CITY OF ALBUQUERQUE PLANNING DEPARTMENT May 8, 2013 DRB Comments

PROJECT # 1001928

APPLICATION # 13-70524

RE: Block 48, NM Town Co. Original Townsite

PLAT OF
LOT 1-A AND 13-A, BLOCK 48
 NEW MEXICO TOWN COMPANY ORIGINAL TOWNSITE
 PROJECTED SECTION 19, TOWNSHIP 10 NORTH, RANGE 3 EAST, N.M.P.M.
 TOWN OF ALBUQUERQUE GRANT
 ALBUQUERQUE, BERNALILLO COUNTY, NEW MEXICO
 APRIL 2013

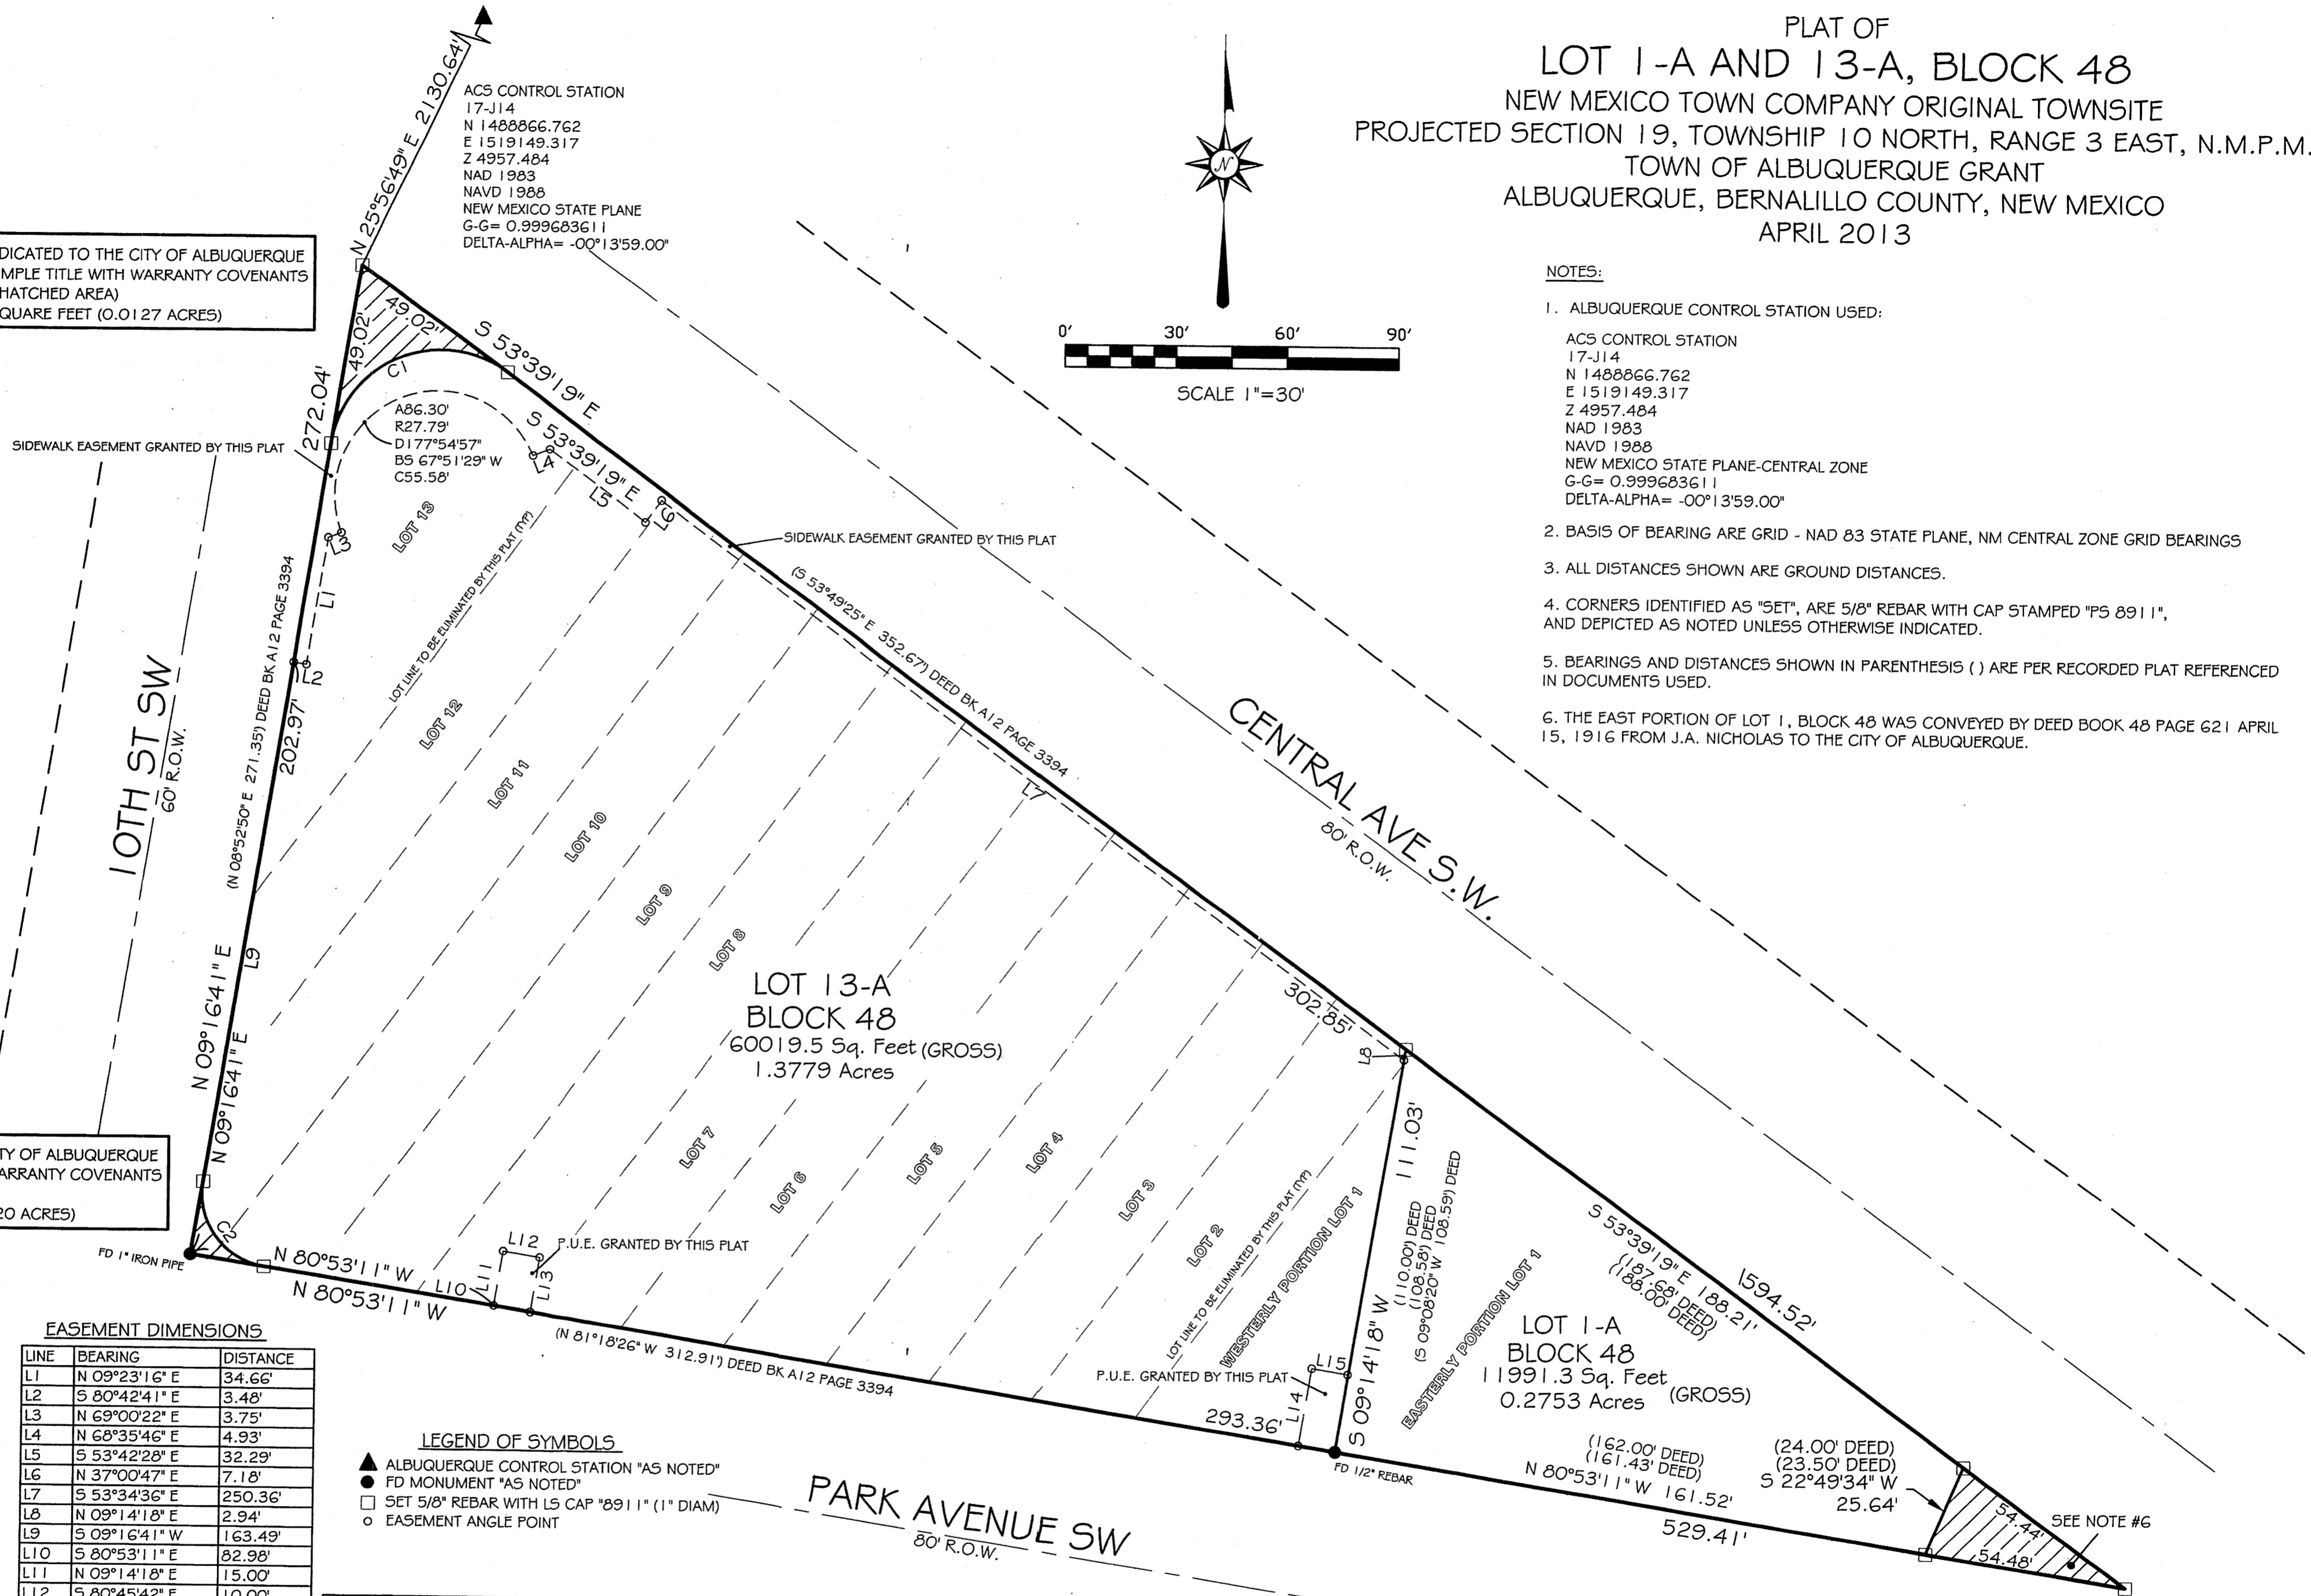
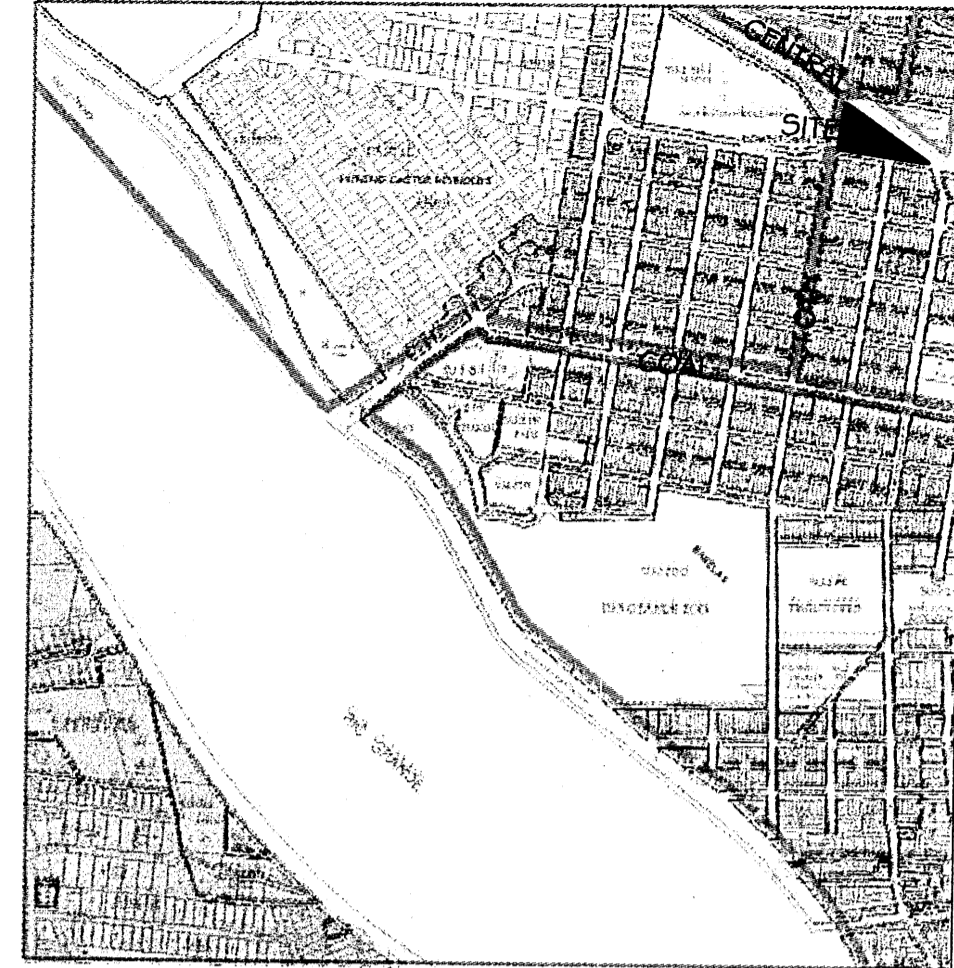
"Current Zoning" note needs to be removed from plat.
